Subject: Planning application F/4/20/OUT Ford Airfield development consultation response

Govia Thameslink Railway (GTR) objects to this proposal unless access to Ford station for active travel modes is provided as outlined in Network Rail's response and road access from the development is provided in a way that does not increase traffic on Ford Road and preferably decreases this traffic as congestion on Ford Road already inhibits use of Ford station.

Nigel Searle MBE MILT
Strategic Planning
GoVia Thameslink Railway

FIGURE 23: KEY PRINCIPLES PLAN – PEDESTRIAN AND CYCLE MOVEMENT

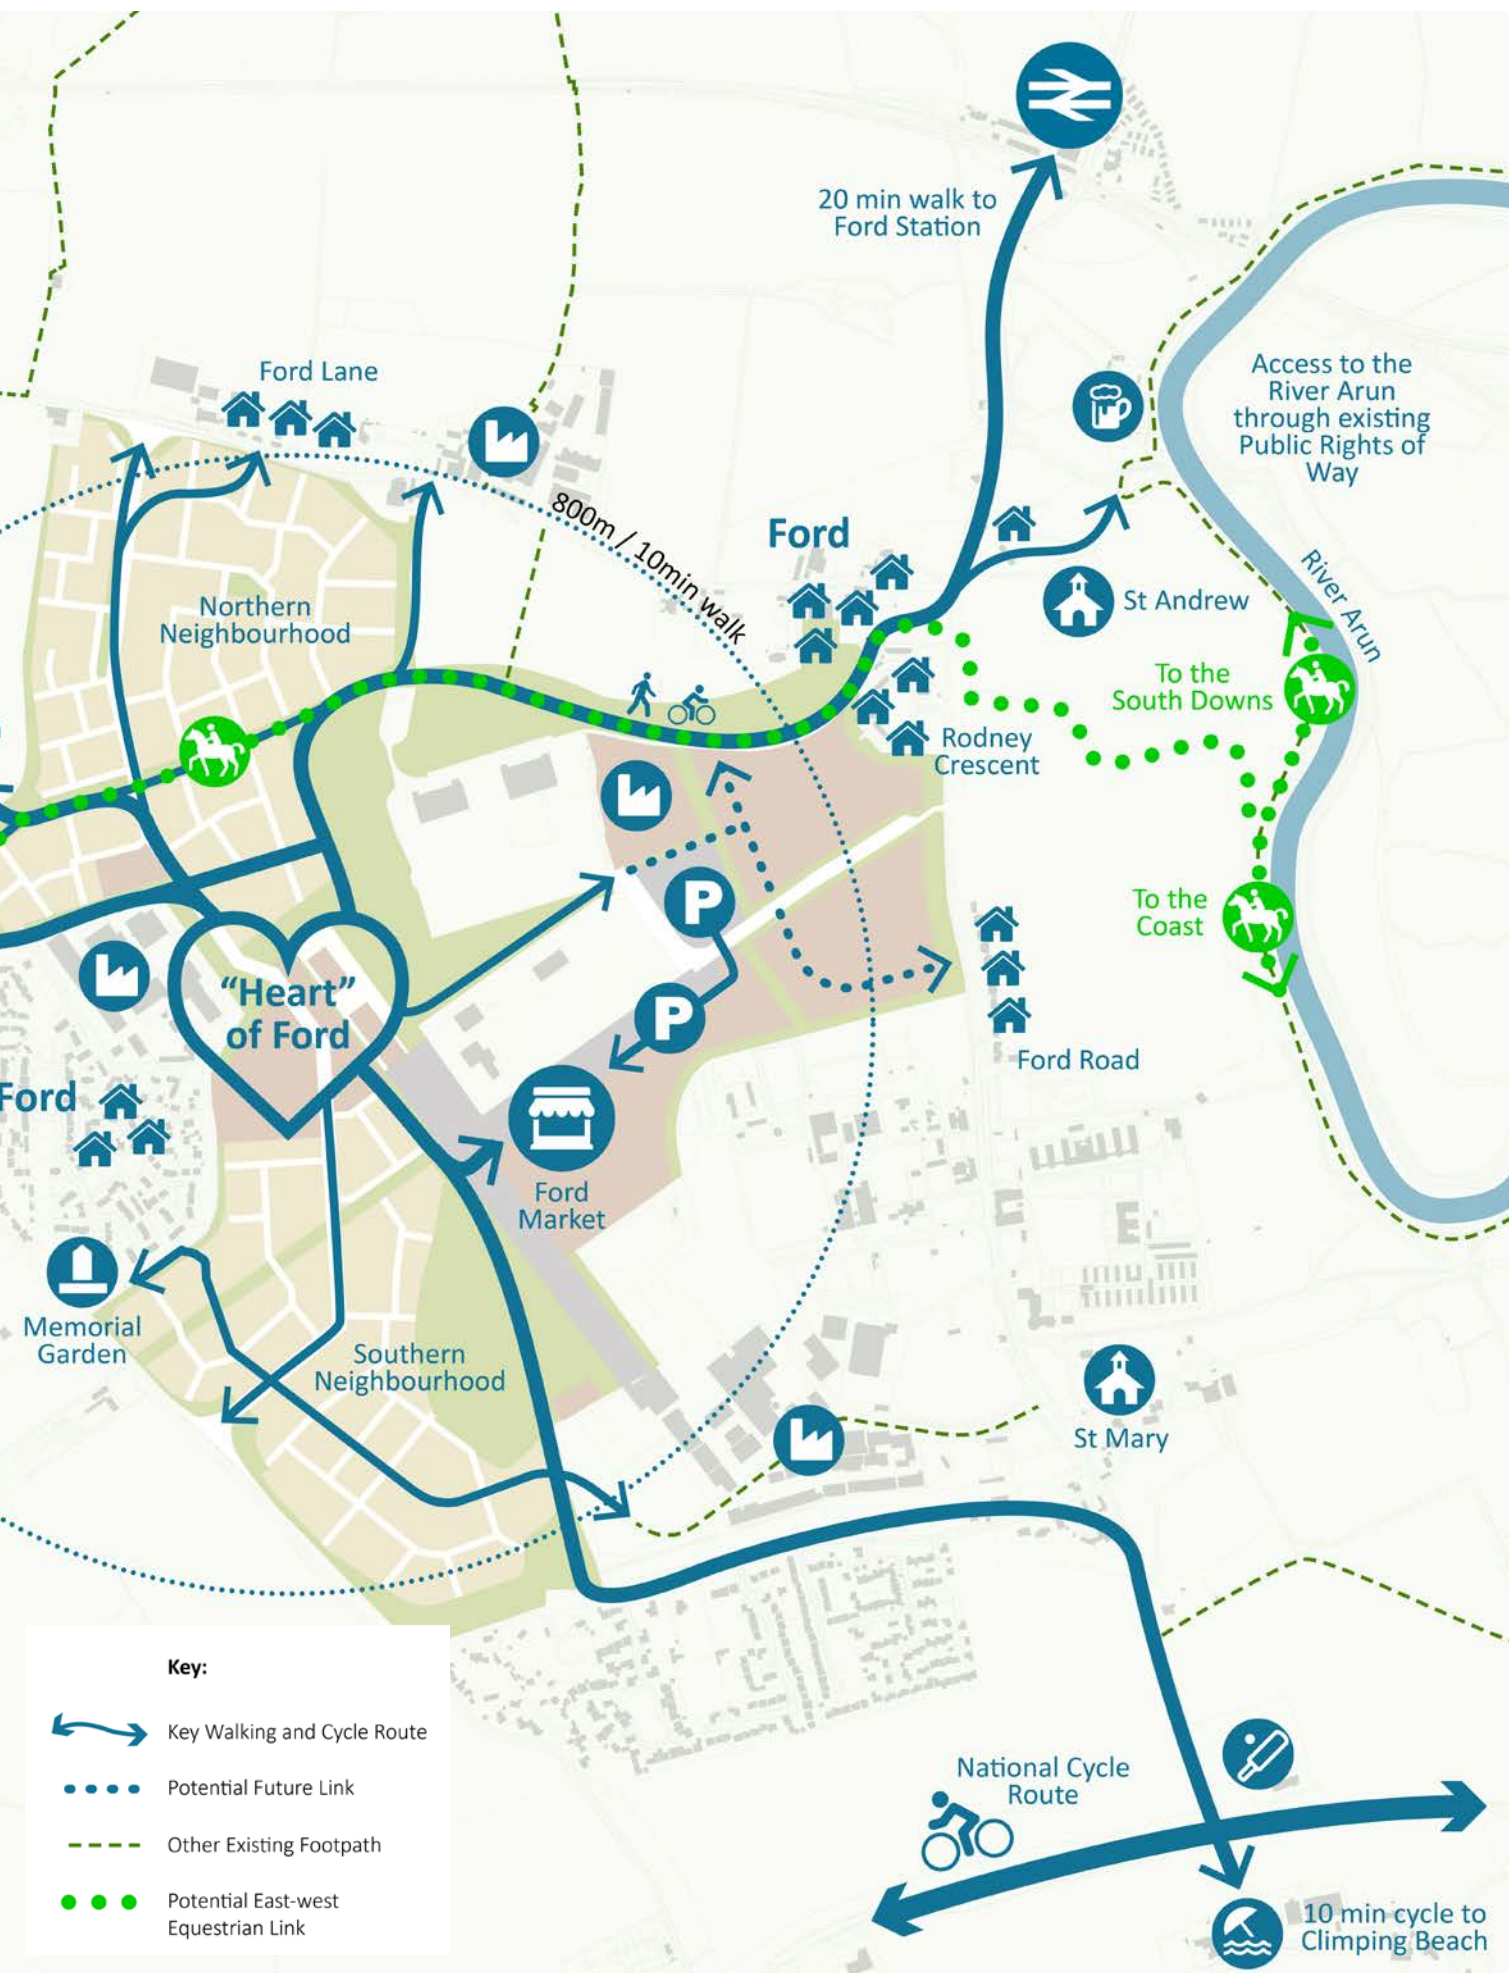
To encourage active travel and promote sustainable transport in line with Policy T SP1 of the Arun Local Plan 2011-2031, there is a need for continuous, direct, safe, attractive and comfortable cycle and pedestrian route to link the new development with Ford Station. This new cycle path could also continue south to join National Cycle Route Network 2 (NCRN2) which consequently would link Clymping with Ford Station. The cycle and foot paths could continue north of Ford Station to provide a continuous direct and safe link to the centre of Arundel benefiting both tourists and residents.

As stated previously these cycle and pedestrian routes must be direct and continuous whereby they do not cross any roads. Where these routes pass over a road, vehicles must stop, give way and only proceed when clear of walkers and cyclists as shown in the photographs below.

FIGURE 24: KEY PRINCIPLES PLAN: VEHICULAR MOVEMENT

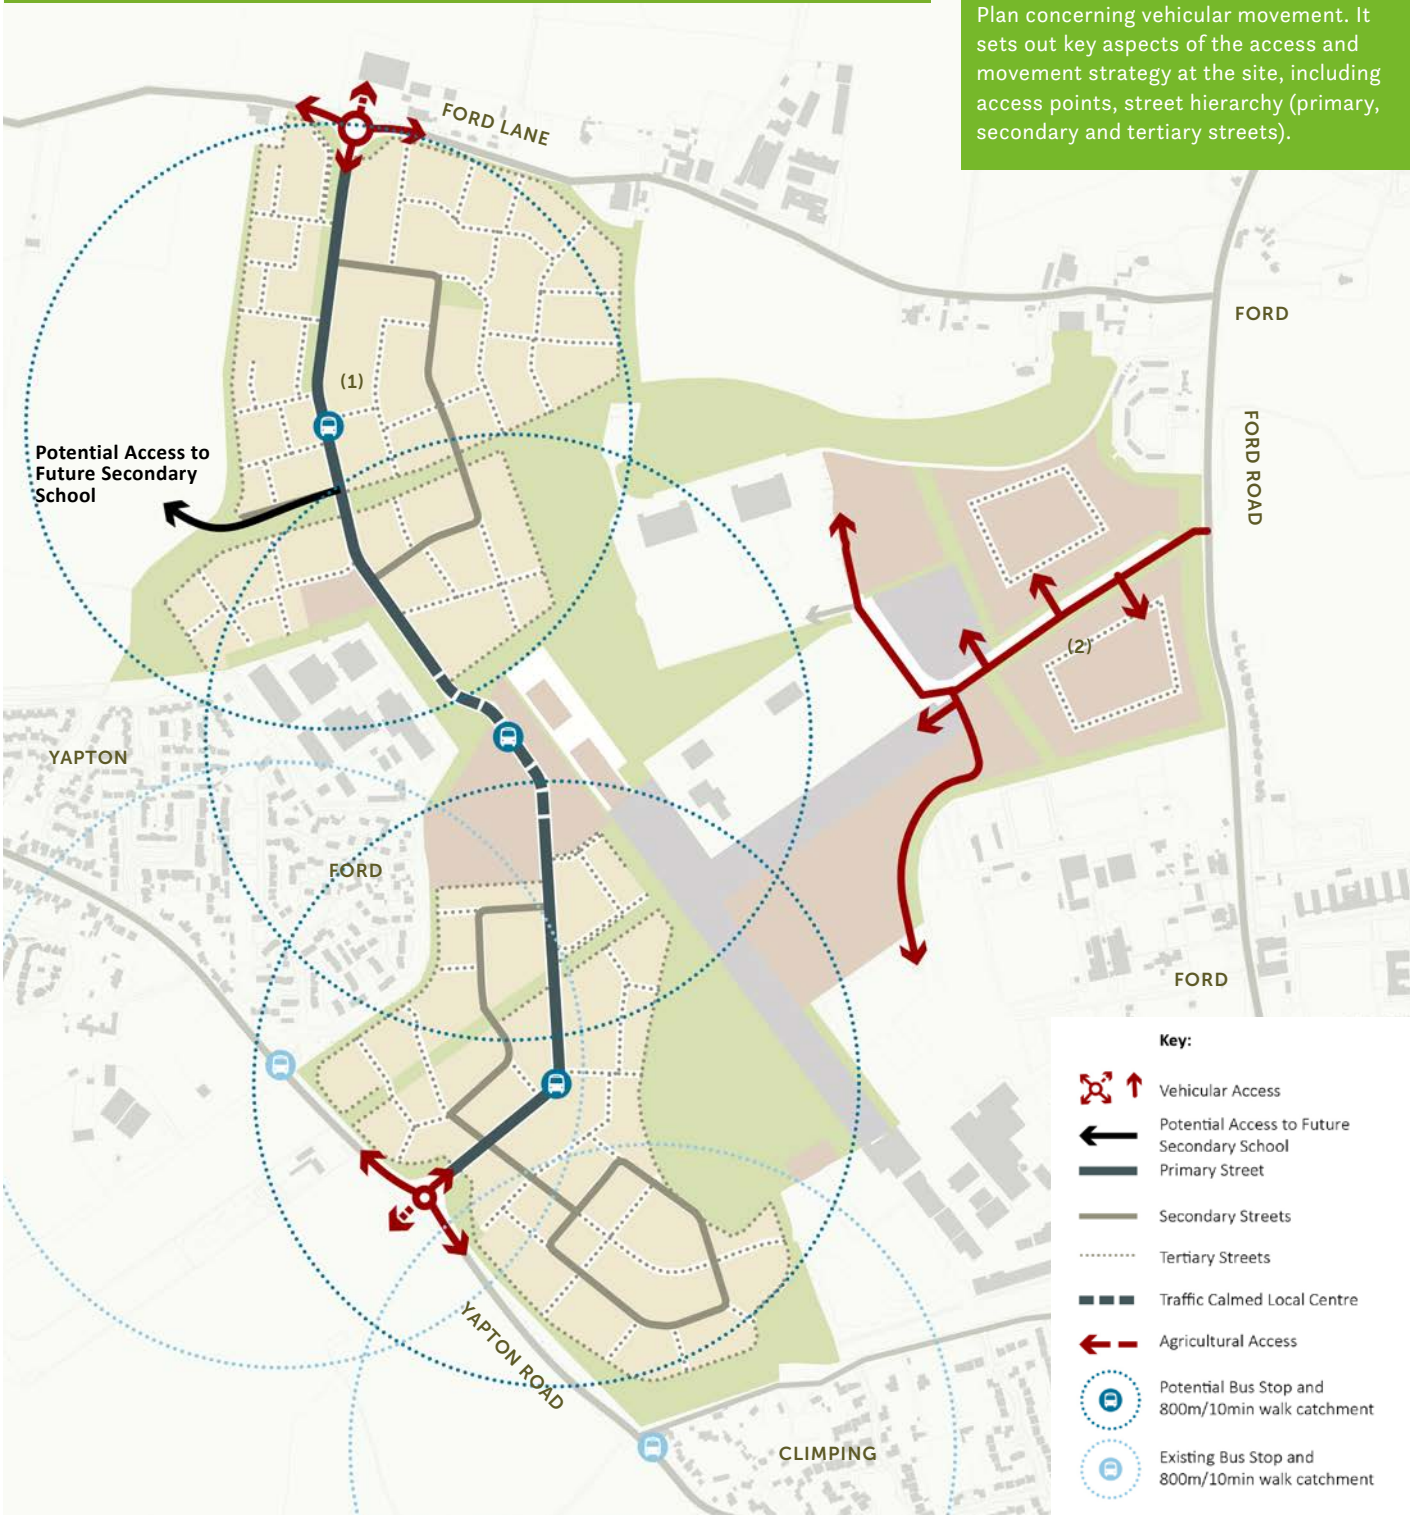
The main access from the new developments' primary street to the north is midway along Ford Lane about halfway between Ford and Yapton Level crossings. To link the new development and Ford industrial estates with the A27 a short stretch of new highway should be built from the junction of the new developments' primary street with Ford Lane via a new bridge over the railway to the existing B2132 Yapton Lane. Ford Lane should be upgraded to B road

B2132 has an AADT of 10,951 and is a road that could accommodate an increase of traffic as it is wide enough for vehicles to pass in both directions for its entire length, though Ford Lane would need to be widened between the new development and North End Road to be upgraded to B road standard as outlined above.

Once the main flow of traffic has been diverted away from the unsuitable Ford Road to the B2132 then it will be worth considering a bridge at Ford to close Ford level crossing from a safety perspective. Though from a traffic perspective it may be better to leave the level crossing to minimise traffic so that Ford Road is used primarily for access to Ford station and properties along Ford Road and not a route for through traffic between Ford Airfield development, Climping or A259 and A27
